App No: P/116/19/OUT

Address: Land adjacent to Sefter School House Sefter Road Bognor Regis PO21 3EE

Proposal: Outline application with all matters reserved for the erection of 4 No. semi- detached 3-bedroom houses & 2 No. detached 4-bedroom houses with associated access, parking & gardens. This application is a Departure from the Development Plan.

**Drawing:** Block/site layout plan – scale 1:500 @ A3

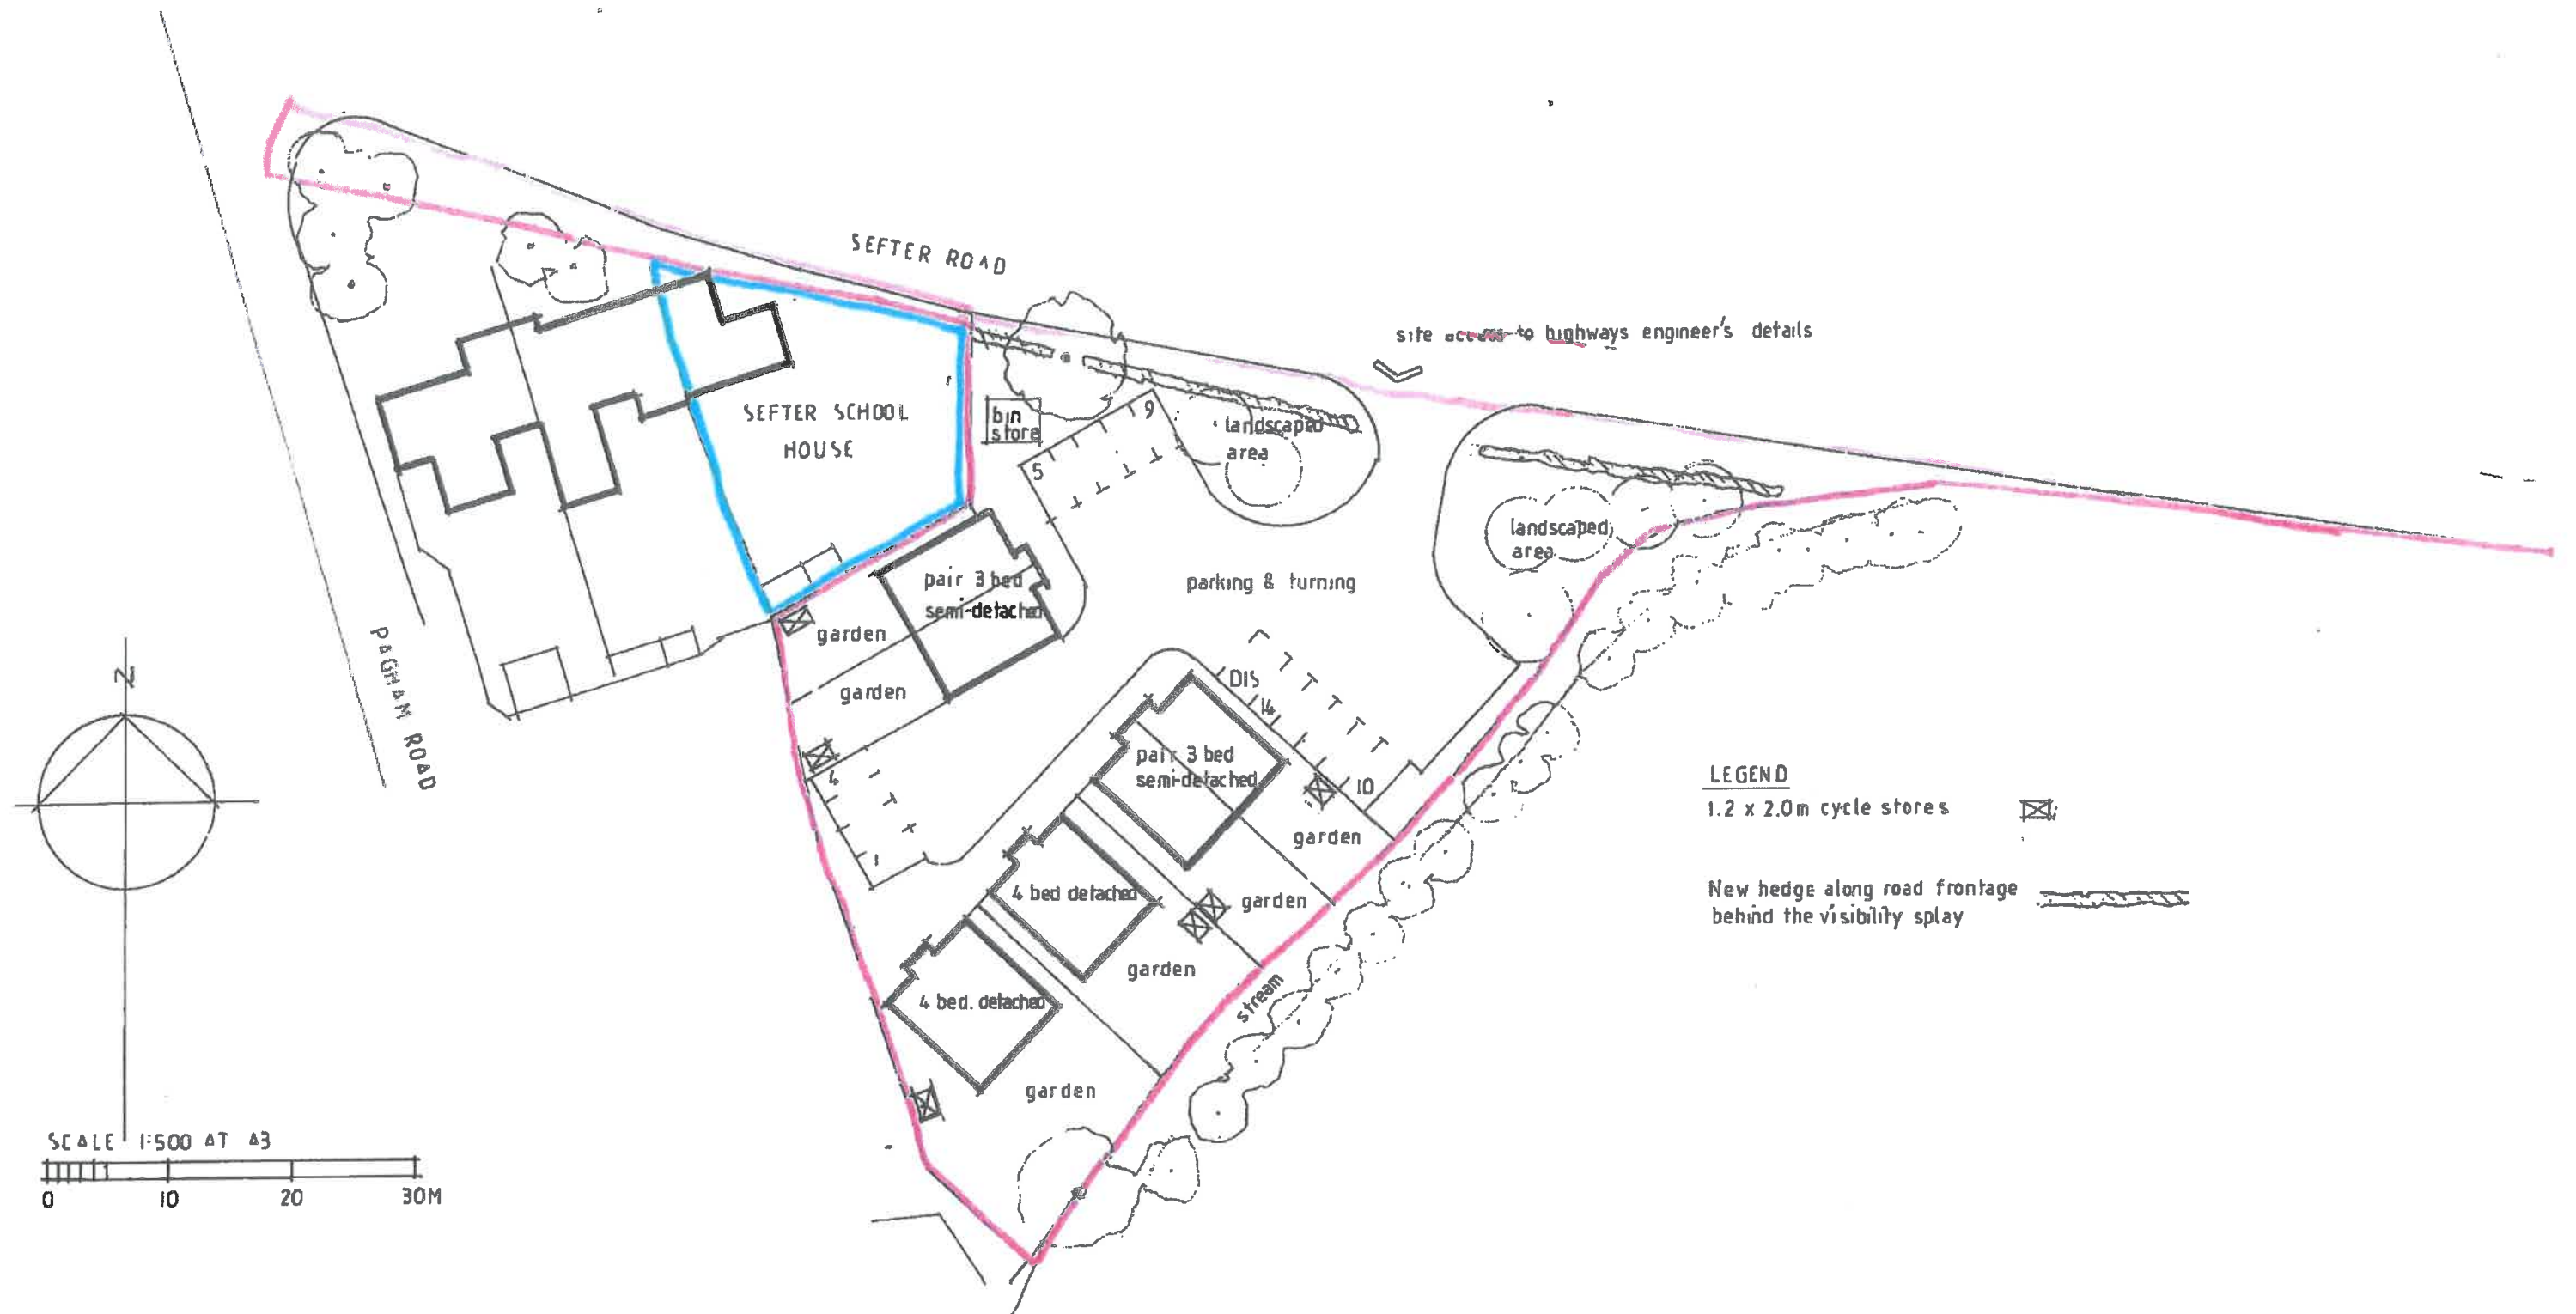
The hedgerows on site are used by bats for commuting and foraging and will need to be retained and enhanced for bats. This will include having a buffer strip around the hedgerows) and during construction fencing should be used to ensure this area is undisturbed. Any gaps should also be filled in using native hedge species to improve connectivity. Conditions should be used to ensure this.

Due to the presence of water voles within the surrounding area and the lack of survey work since 2016 in the ditch onsite no works can take place within this ditch or area and a 5m buffer should be set up from the ditch bank and fencing used during the construction period to ensure this area remains undisturbed. If any works need to take place in this area, then a full mitigation strategy for water voles will be required.
